Location: Clover Cottage Clough Lane Simonstone BB12 7HW
Proposal: Proposed first floor extension to side and extension of driveway.
Grid Ref: 377711 434515

Lancashire County Council acting as the Local Highway Authority (LHA) does not consider that the application as submitted fully assesses the highway impact of the proposed development and further information is required as set out in this response.

Proposed Ground Floor Plan (unaltered)

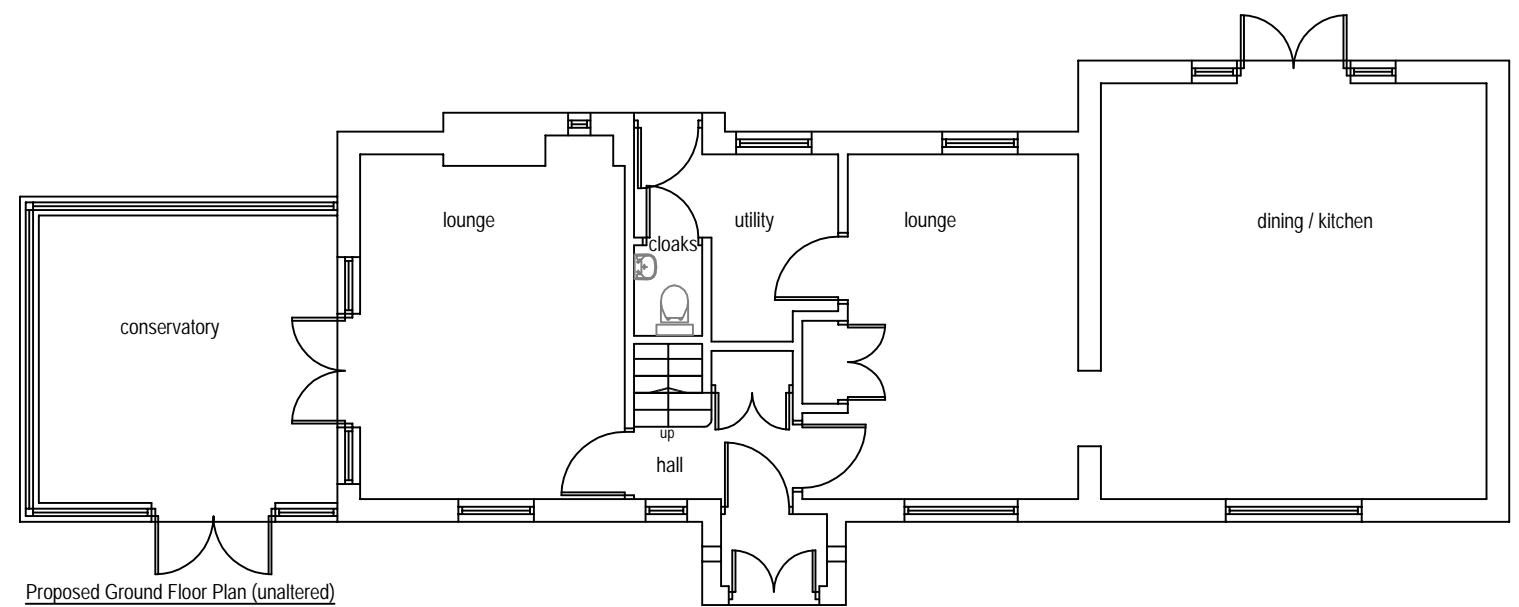
The LHA have reviewed the proposal and note that the development will increase the number of bedrooms within the site as well as increase the parking provisions by one vehicle. Given the nature of the site, the LHA request that the applicant provide further information regarding the gradient of the proposed driveway. It is expected that the driveway has a gradient of no less than 1:10.

Therefore, the LHA request an amended plan which details the proposed driveway gradient.
